Our Ref: MN/7451/App_200521.
20th May 2021

**Re: Planning application at 69-71 Church Road, Anerley, Crystal Palace, SE19 2TA
Variation of Conditions 2 & 9 Application.**

On behalf of our client, we write in support of a Variation of Conditions application for the conditionally approved project at 69-71 Church Road, Anerley, ref: DC/19/03203/FULL1. The submitted information looks to vary **condition 2** by superseding the approved drawings with the drawings submitted as part of this application.

Rev	Date	Comments
<b>PLANNING</b>		
Client AVF DEVELOPMENTS		
Project 69-71 CHURCH ROAD ANERLEY CRYSTAL PALACE SE19 2TA		
Title PROPOSED PLANS THIRD AND FOURTH		
Project No. <b>7451</b>	Date MAY 2021	
Drawing No. 7451-PD-202	Revision	
Scale 1:100 @ A3	Drawn MN	Check RC

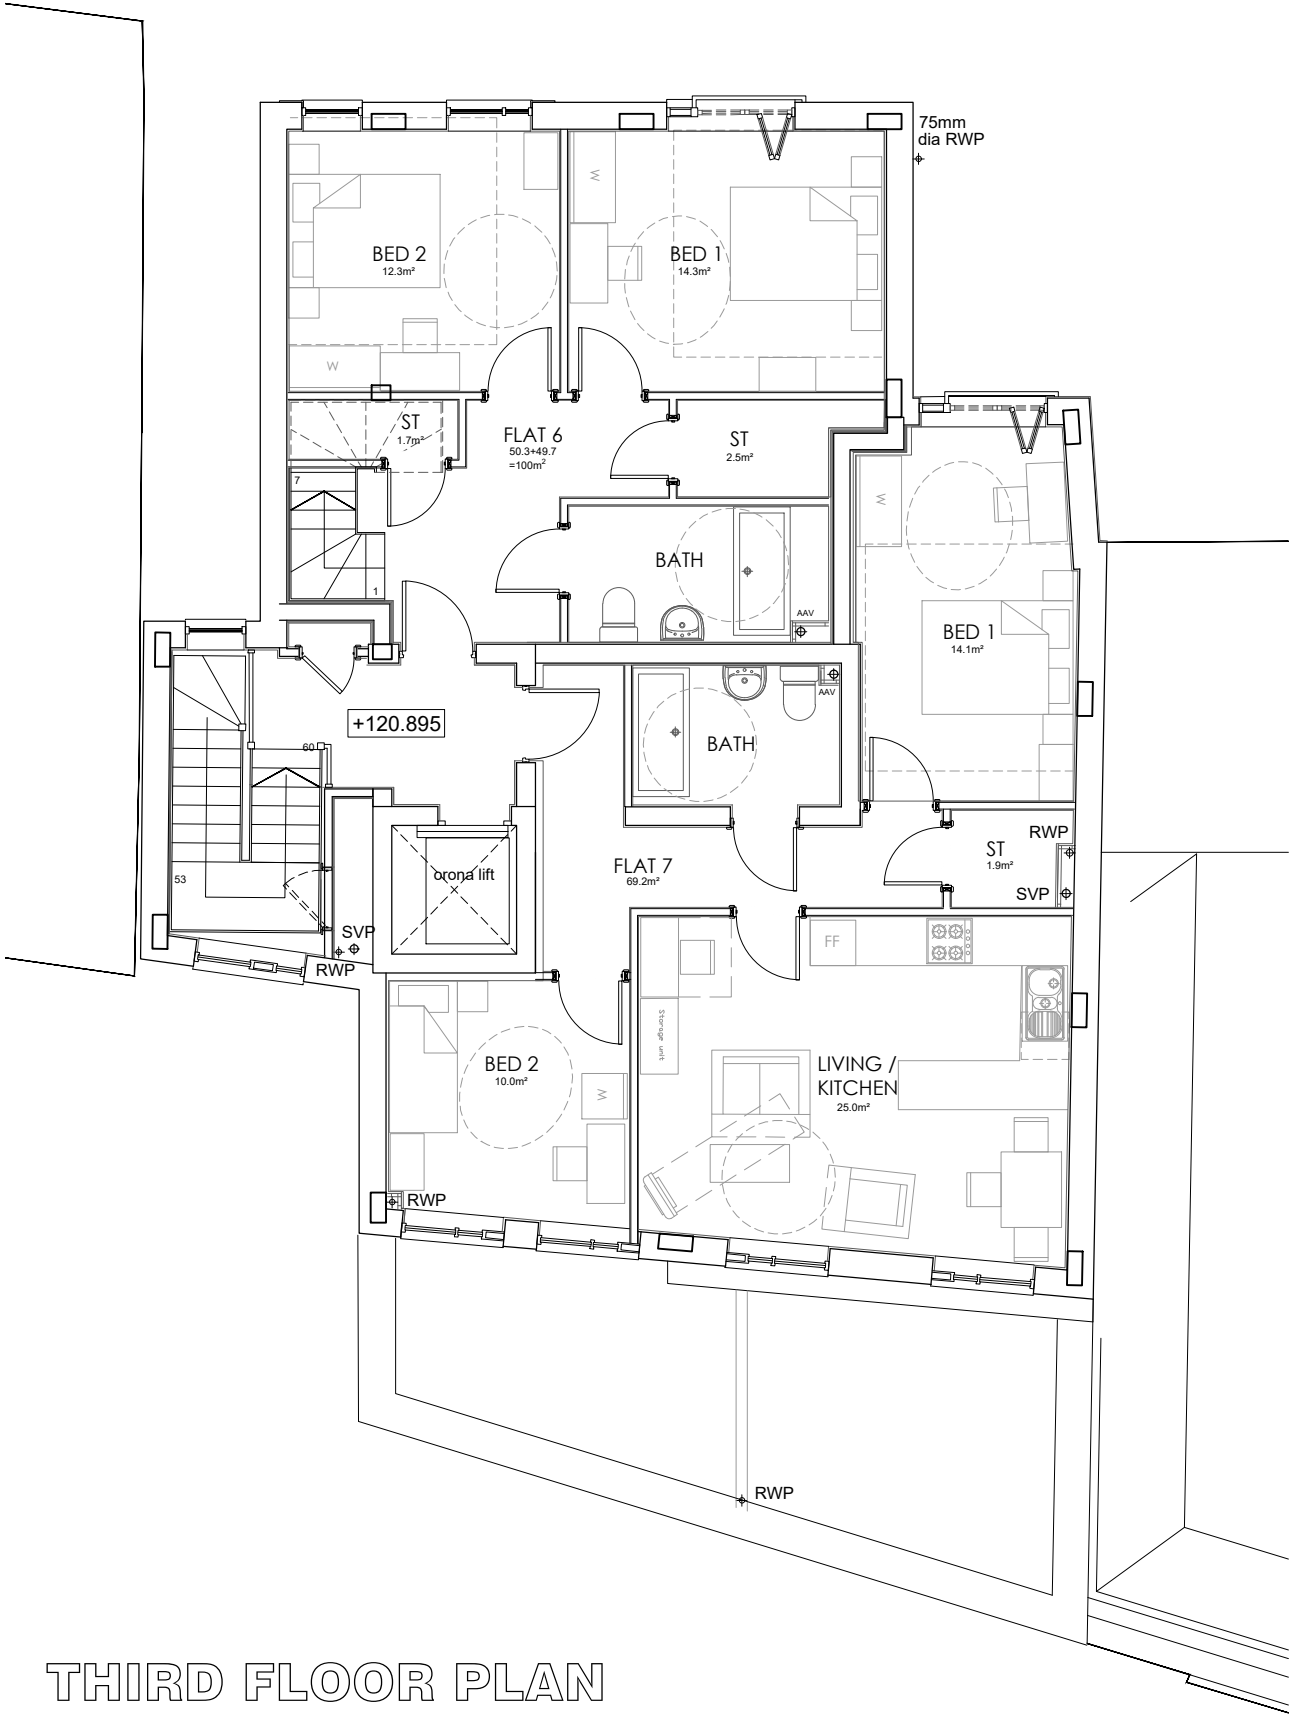
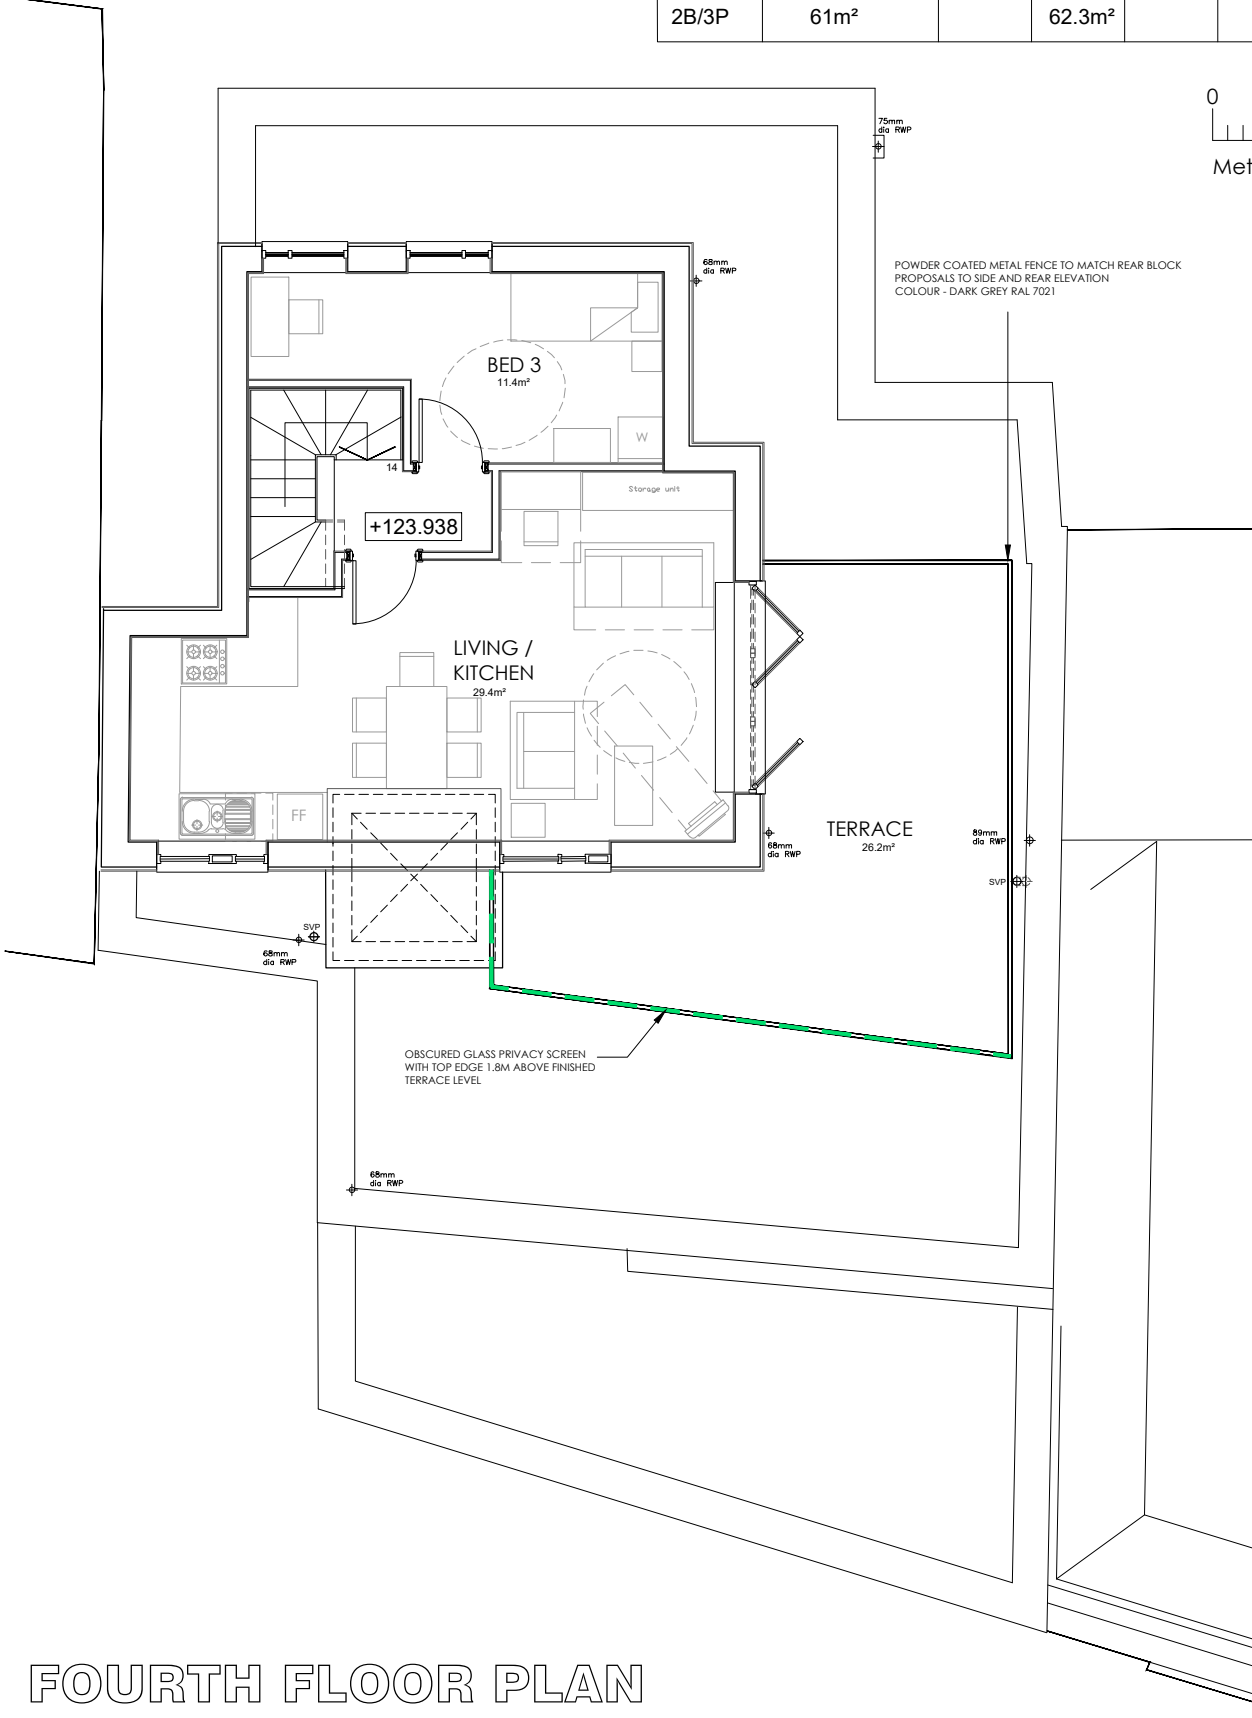
Drawing G686_1103_B to be superseded with **7451-PD-202**

Part of the fire strategy also required limiting the number of apartment doors accessing the stair core and therefore the entrance door to flat 1 has been relocated to the external wall adjacent the communal entrance.

| 7451-PD-201 | |

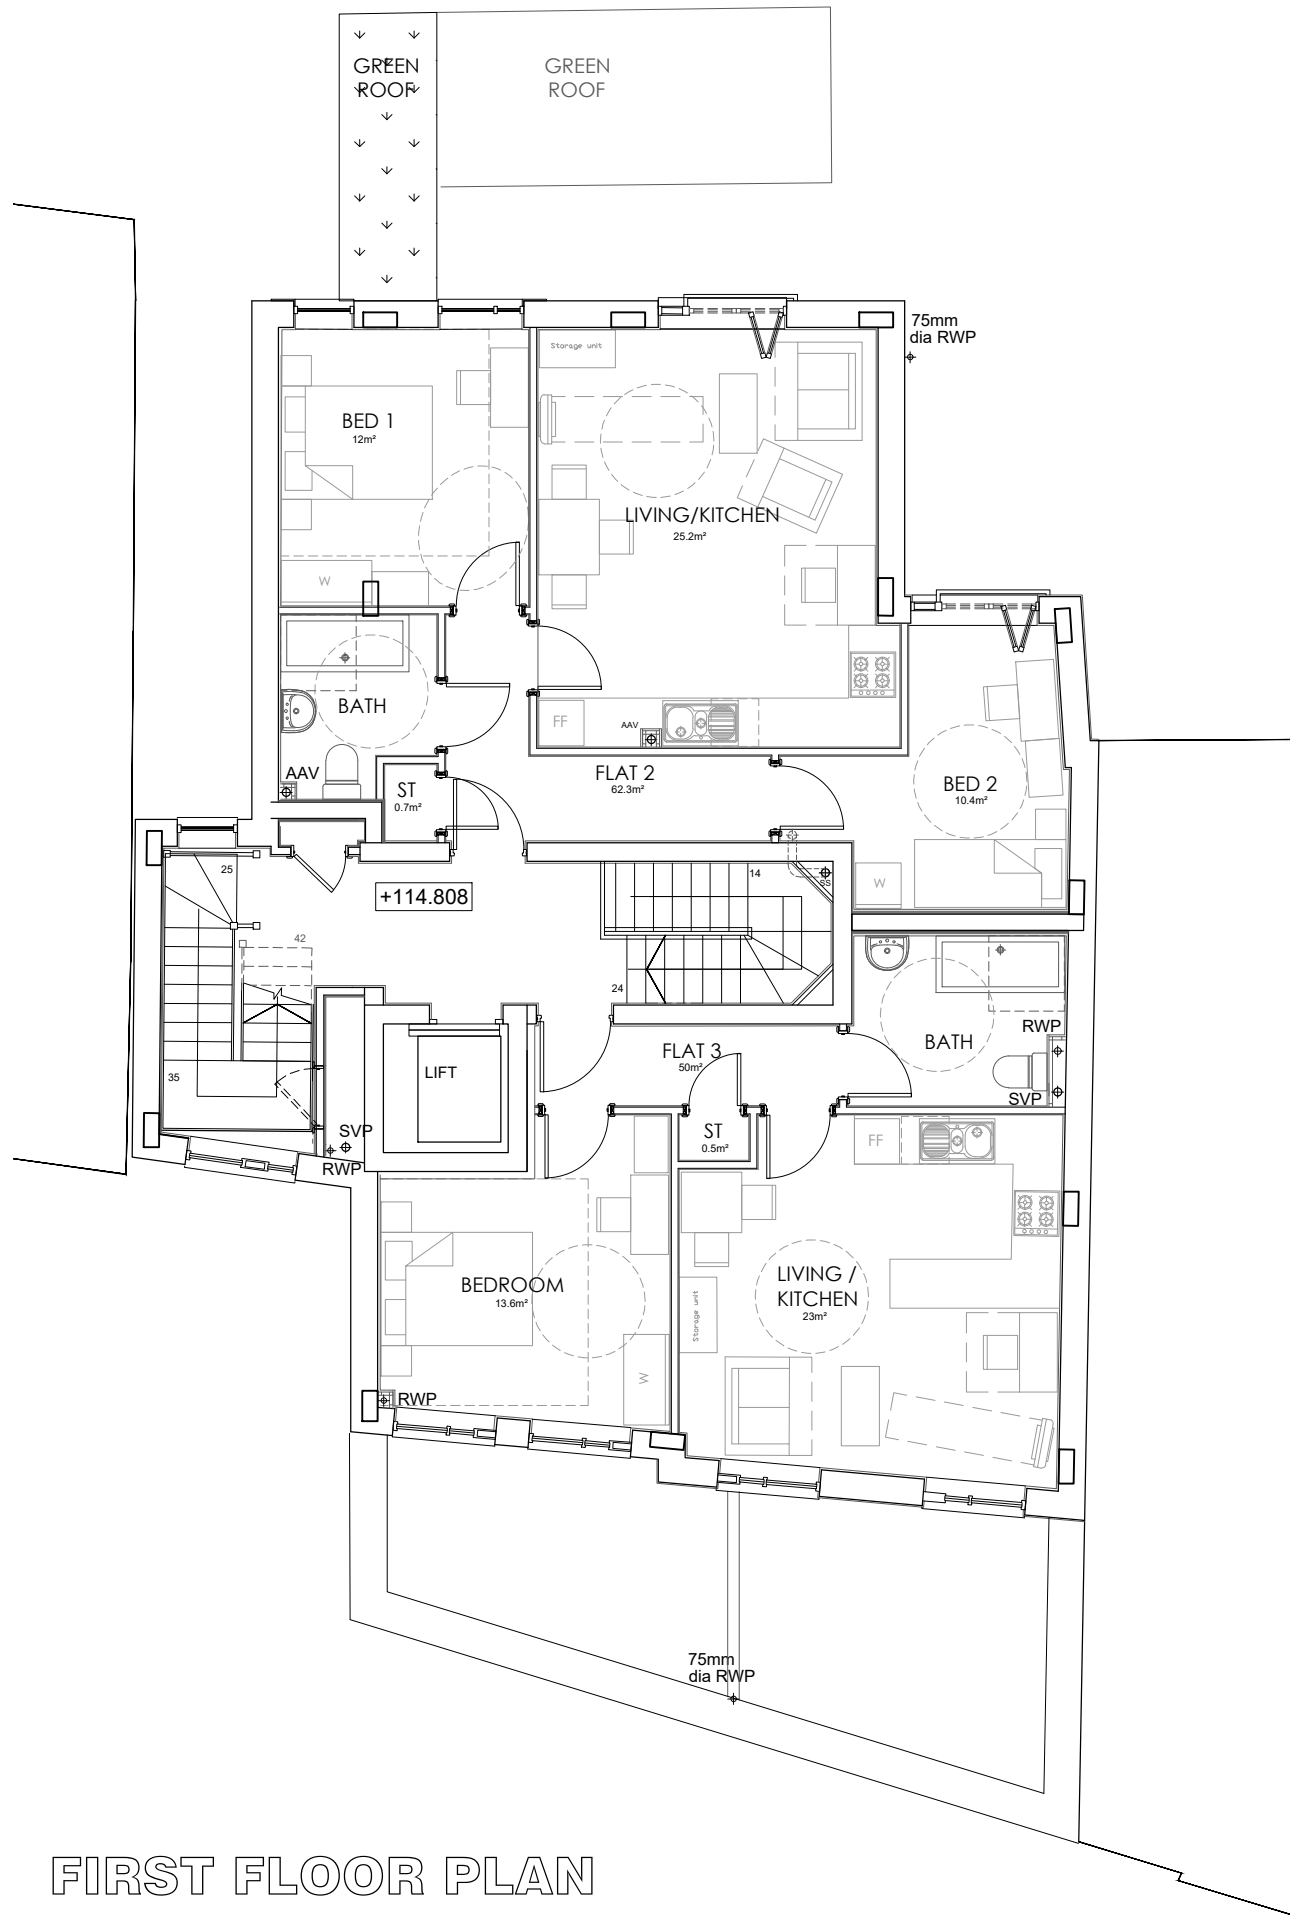
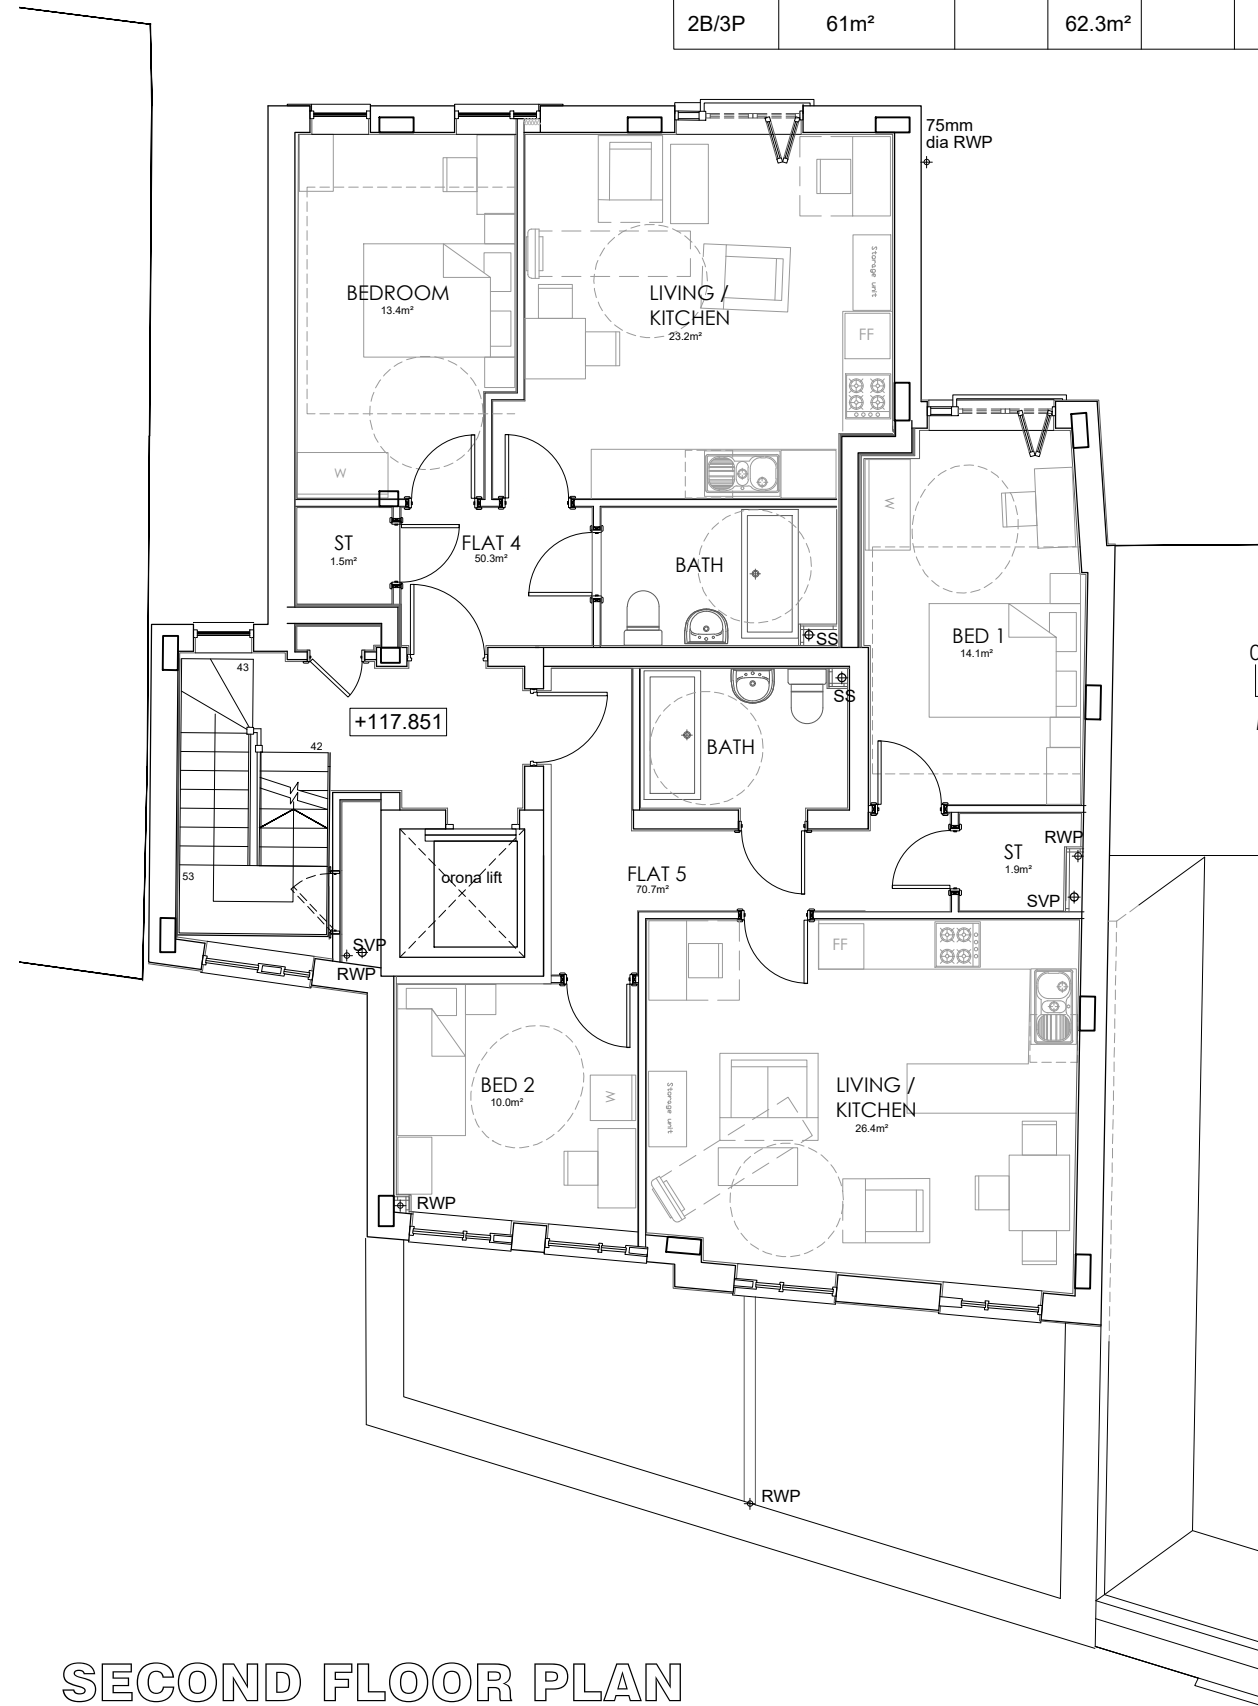
Drawing G686_1102_B to be superseded with **7451-PD-201**

Title
SITE PLAN & LOCATION PLAN

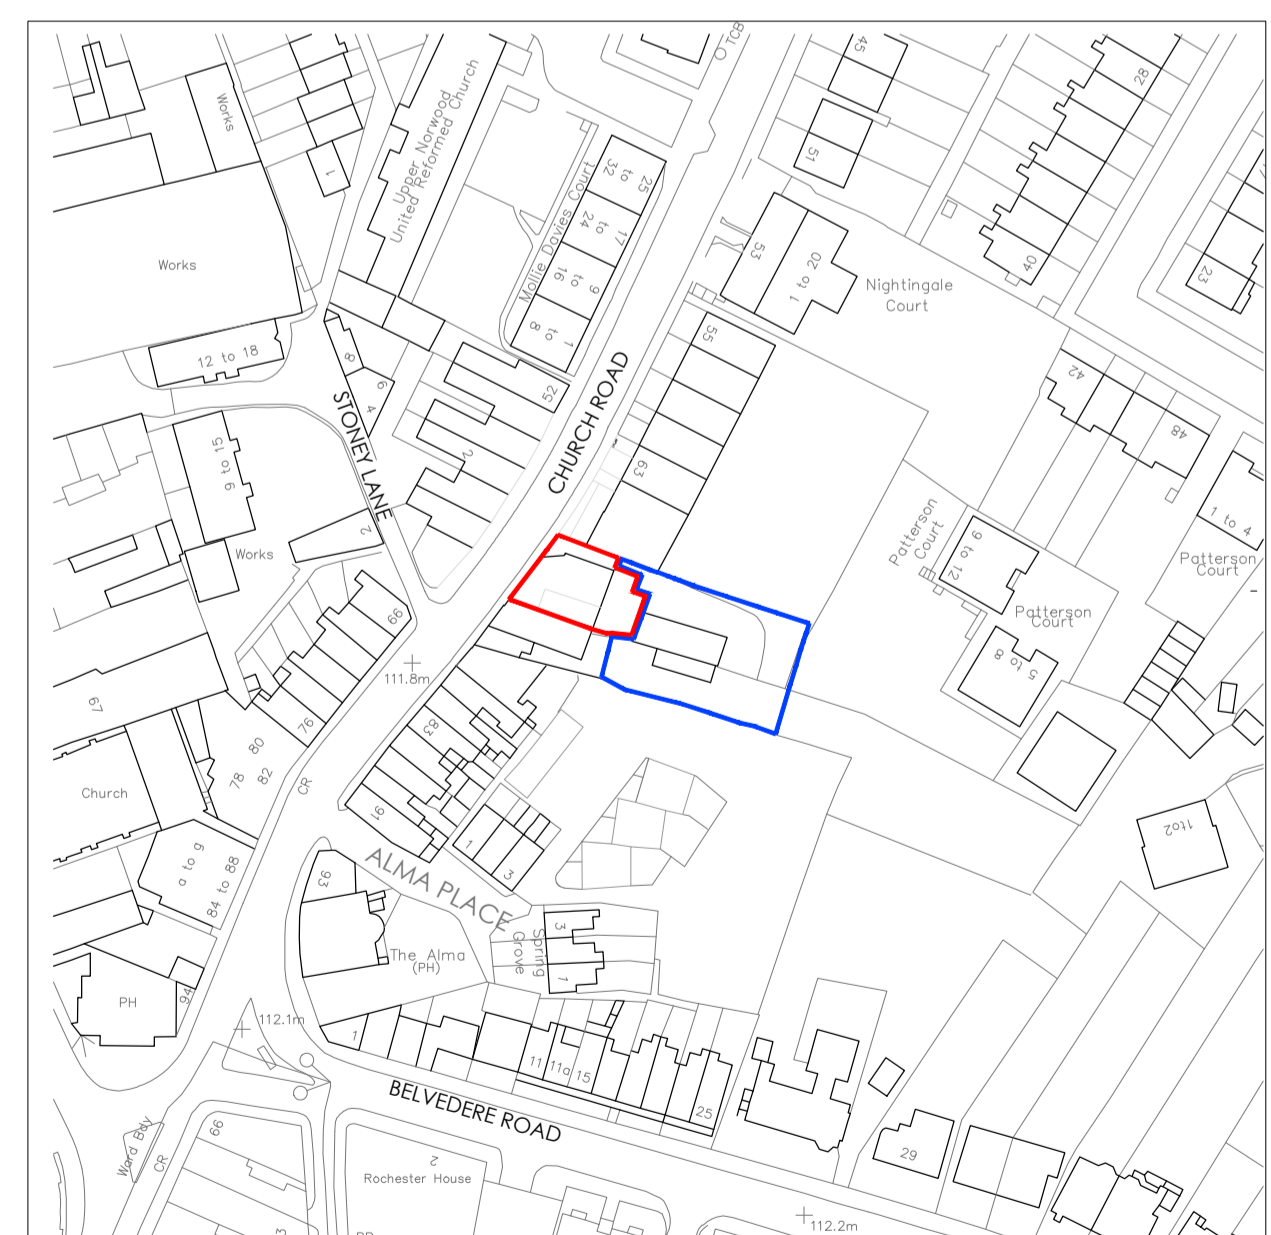
The approved rear block has also meant the amenity space has had to be revised and relocated. It is now proposed to be a shared space serving both apartment blocks and is shown on the plans being submitted.
